**From:** Michael Eastham <Michael.Eastham@arun.gov.uk>  
**Sent:** 04 December 2020 14:25  
**To:** Planning.Responses <Planning.Responses@arun.gov.uk>  
**Subject:** FW: \*EXTERNAL: A/179/20/RES - Land South of Water Lane, Angmering

Please upload onto Ocella the email below which is a further consultation response from the **Local Highway Authority** raising no objection to the reserved matters application (A/179/20/RES) for the culverted embankment on Land South of Water Lane, Angmering.

Please see the email below from Sean Havis at BDW and find attached an amended plan for reserved matters application **A/179/20/RES** relating to the culverted embankment on Land South of Water Lane, Angmering.

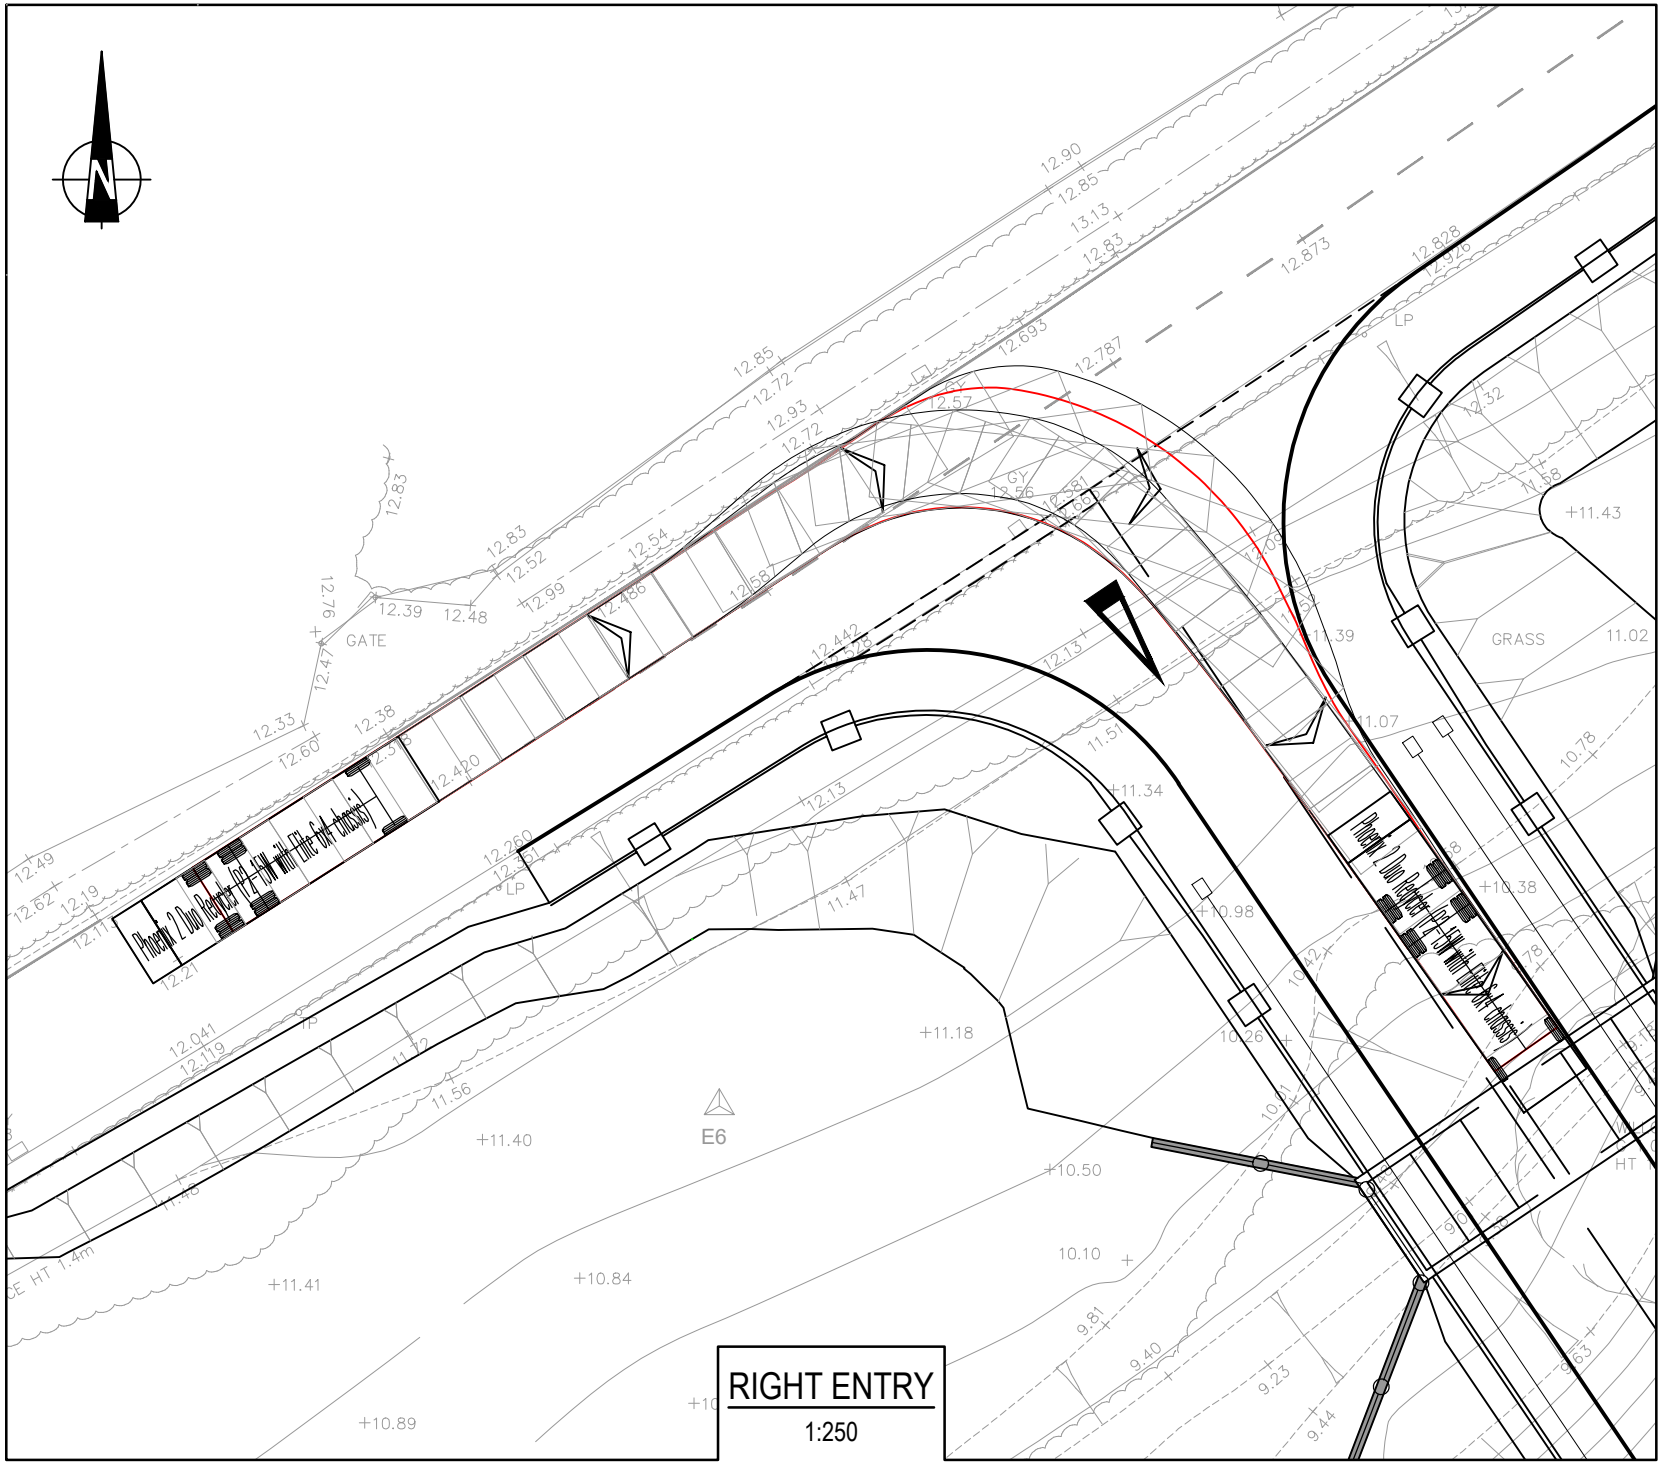
Evidence would be required that there is sufficient access width for a fire appliance to access the site. The road would need to be sufficiently wide enough to allow a fire appliance to gain access with a minimum width of 3.7 metres and capable of withstanding 12 to 17 tonne axial weight.

In regard to the other two queries from the Local Highway Authority and WSCC Fire & Rescue Service, please find the attached revised plan (General Arrangement - 46353\_2002\_020\_A) illustrating the crossing over Water Lane connecting into the footway/cycleway running north and east. The attached plan also demonstrates that the width of the carriageway is 6m, significantly exceeding the 3.7m requirement. I can also confirm that the culvert will be constructed to be capable of withstanding 12 to 17 tonne axial weight.

**WATER LANE, ANGMERING
BOX CULVERT
EXISTING
PLAN, SECTIONS & LEVELS**

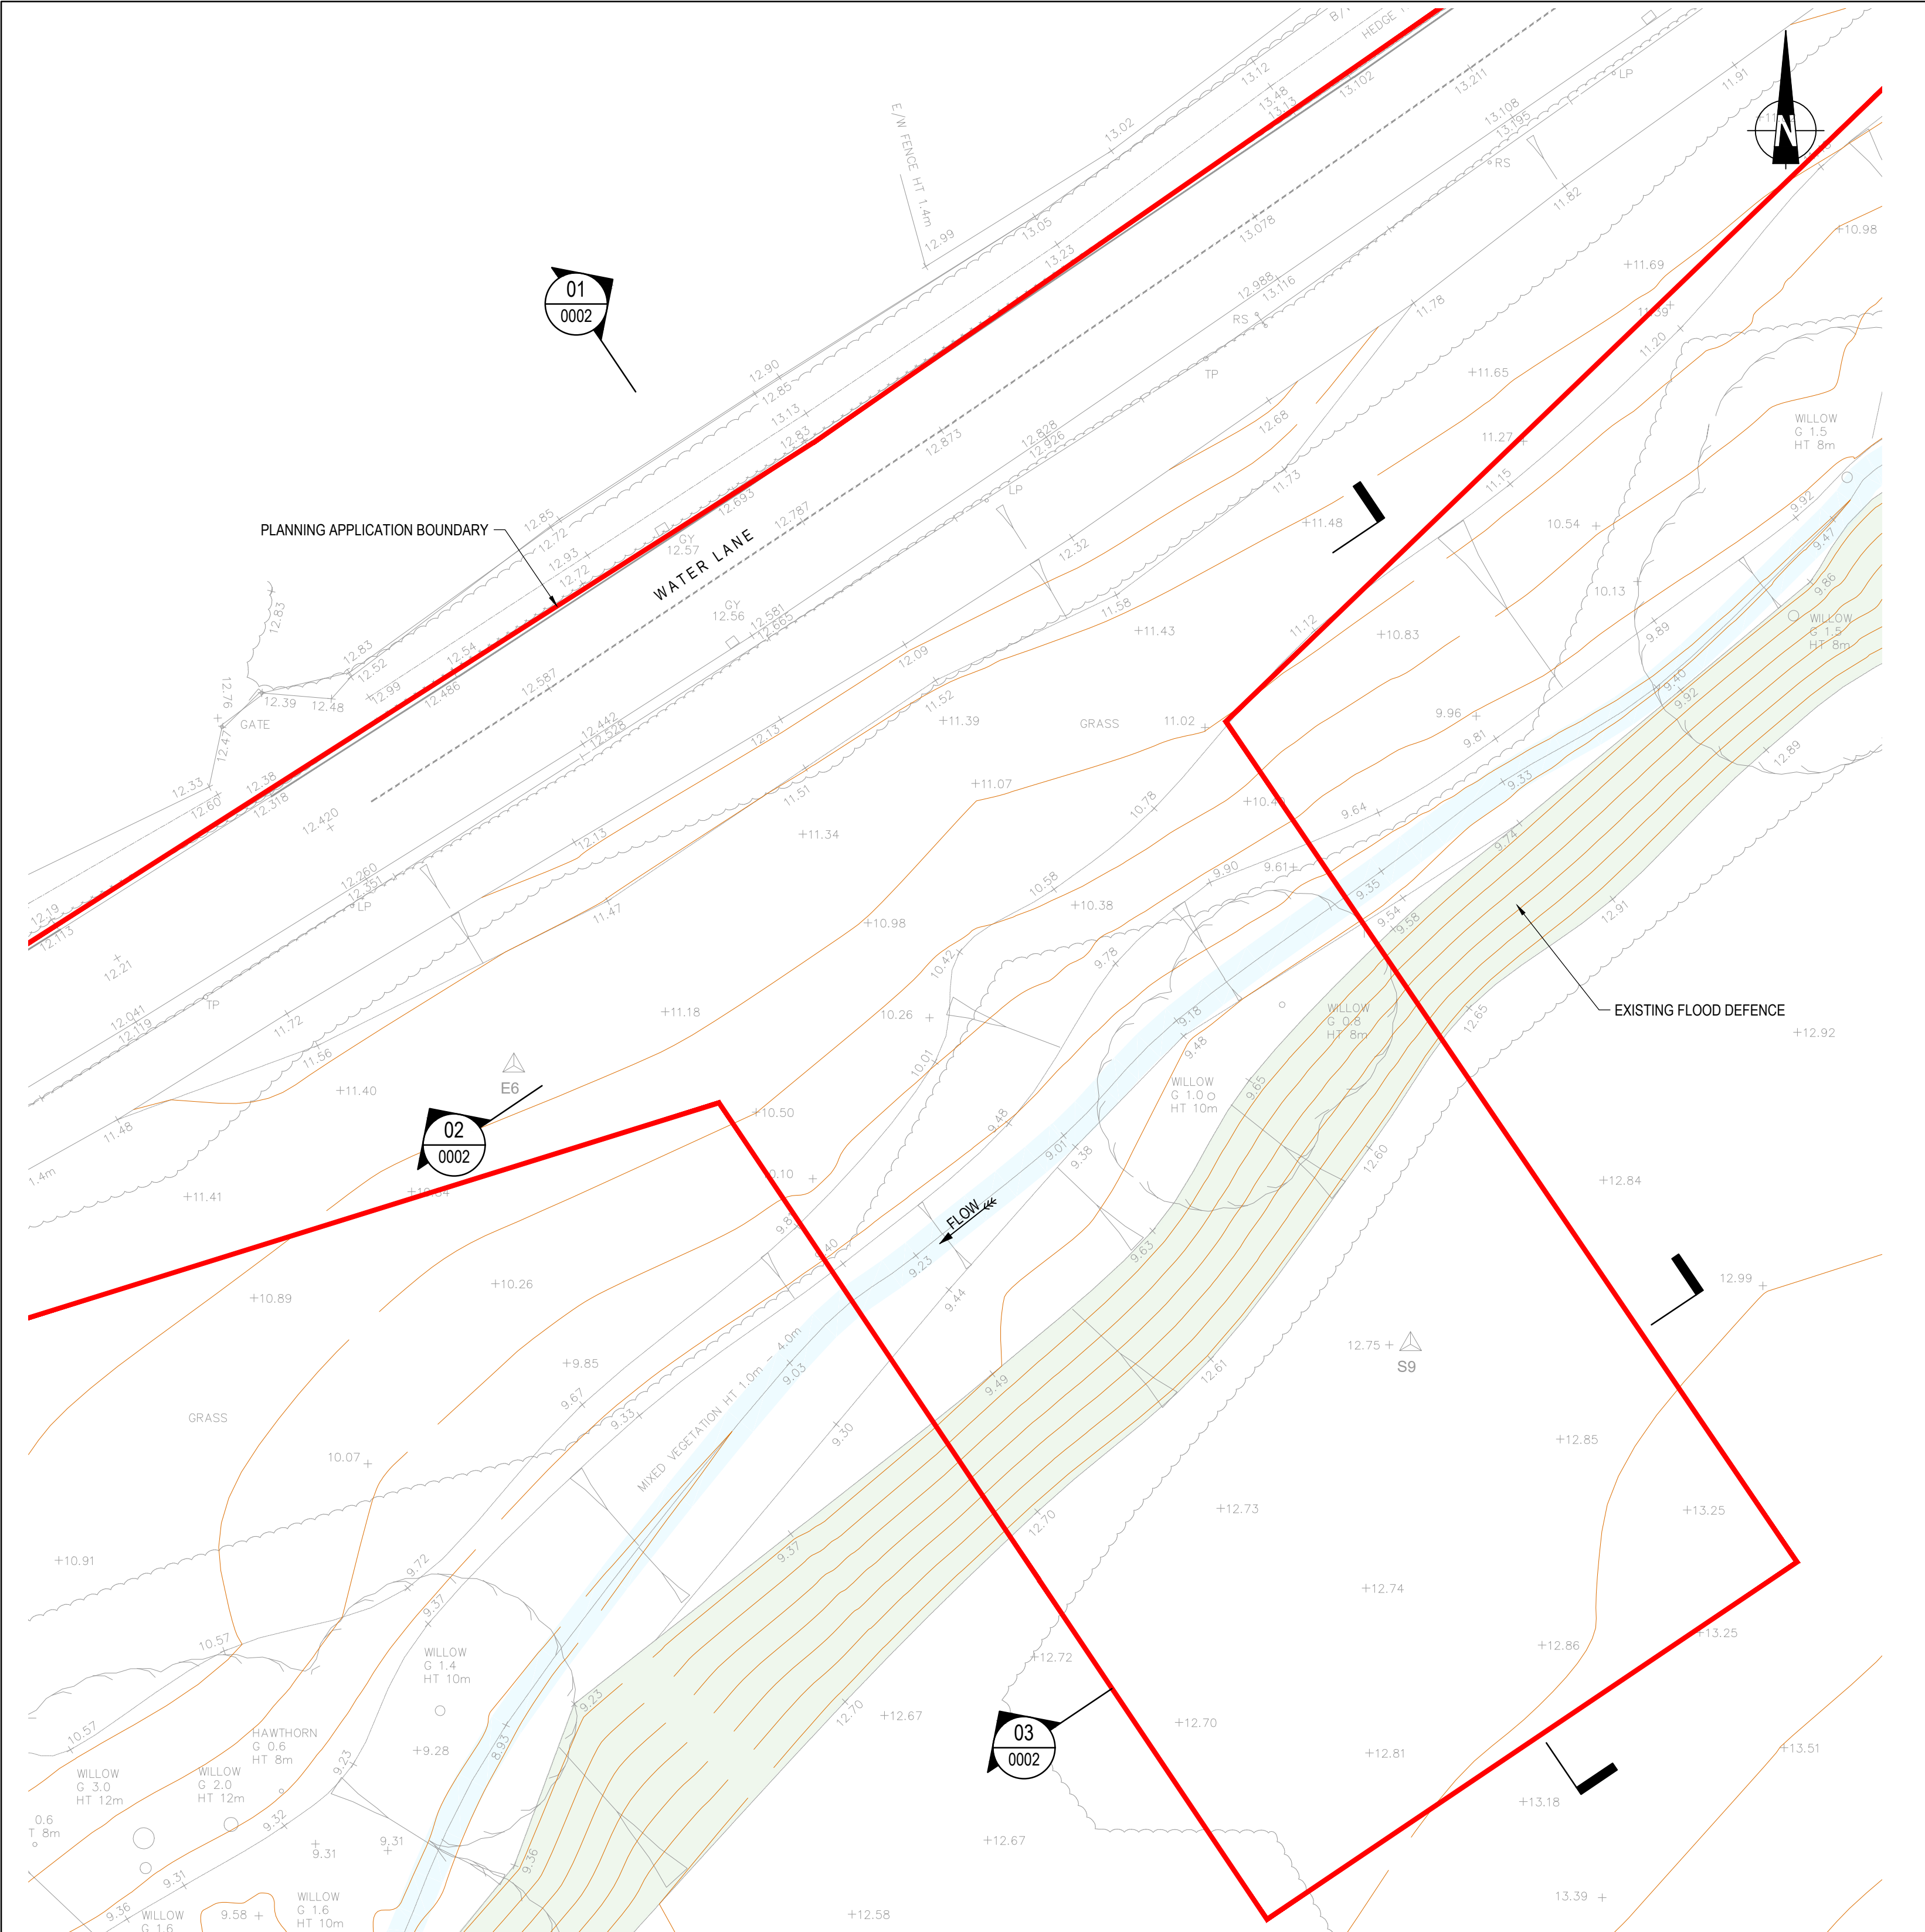
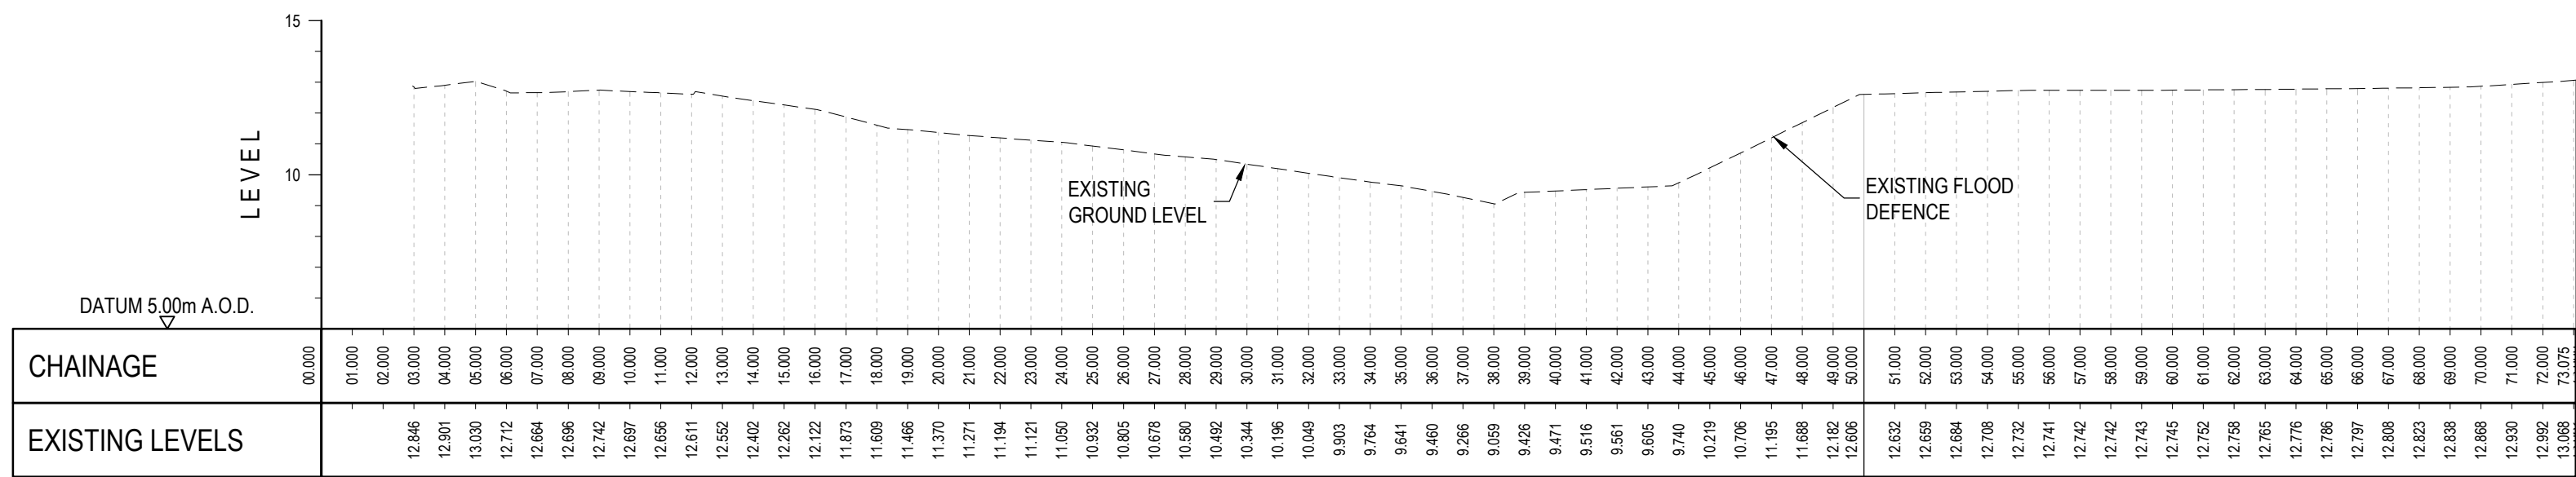
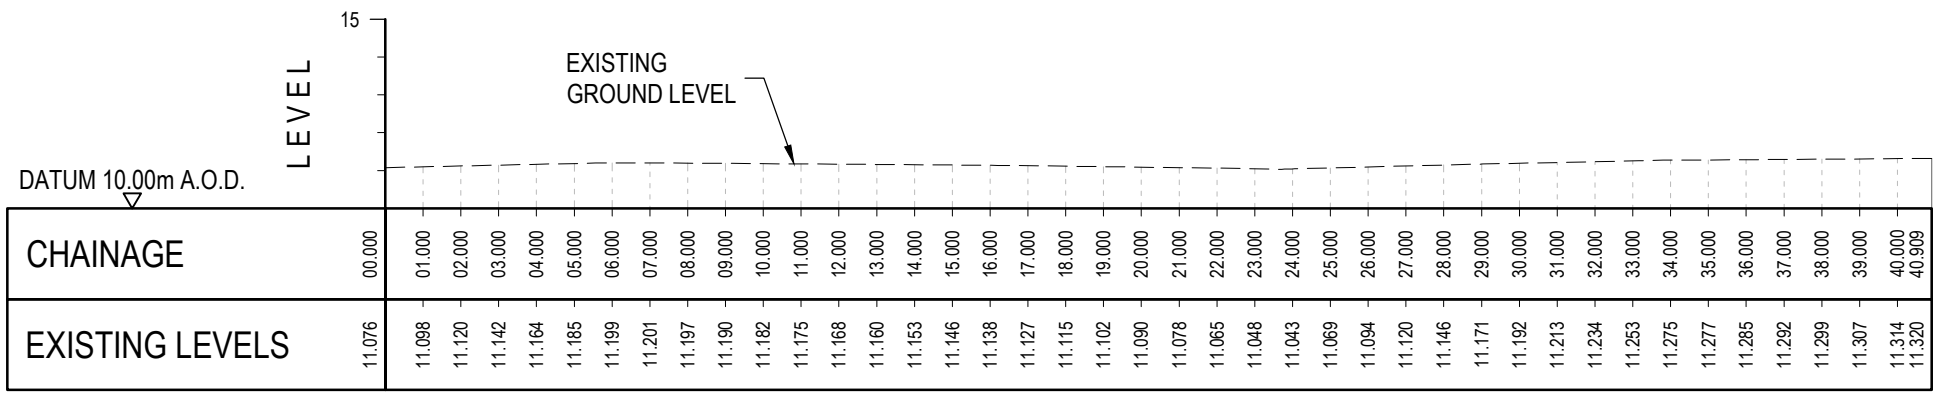
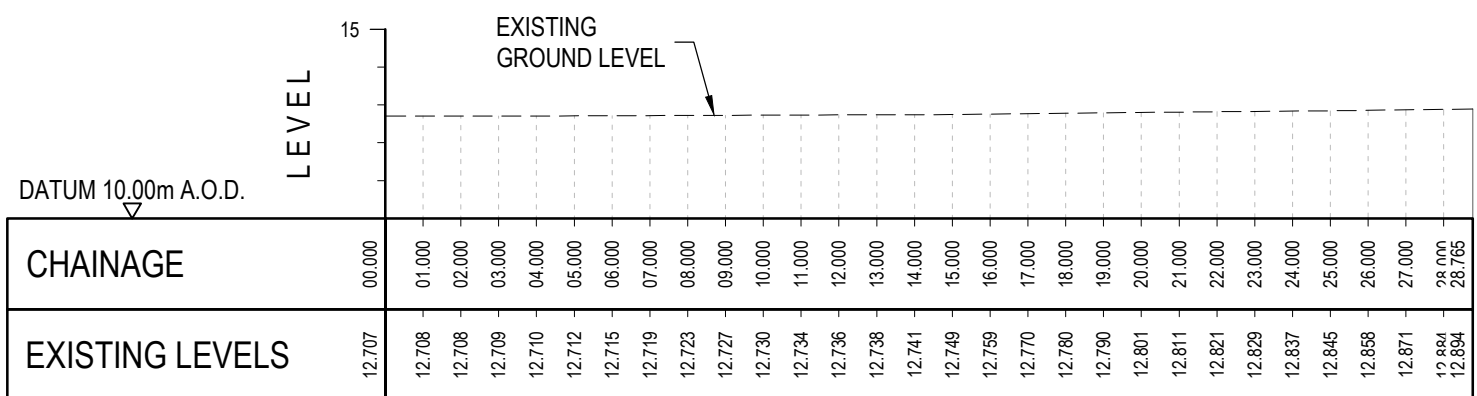
It is understood that the culverted embankment would form part of the Angmering Flood Risk Alleviation Scheme and that in the event of flooding flow would be restricted through the culvert and a holding lake/pond formed against and upstream of the embankment. This is necessary to prevent an excess volume of water overwhelming the culvert at Weavers Hill in extreme flood conditions. The Parish Council wish to see details showing the positioning of the "throttling" at the culvert and have a plan of the lake that would be formed in flood conditions, showing its extent with an indication of its maximum depth. From plans submitted the latter would appear to be approximately 2 metres; can this be confirmed?

I understand Ray Drabble (WSCC LLFA) has responded regarding the Parish Council's query and this has now been addressed.
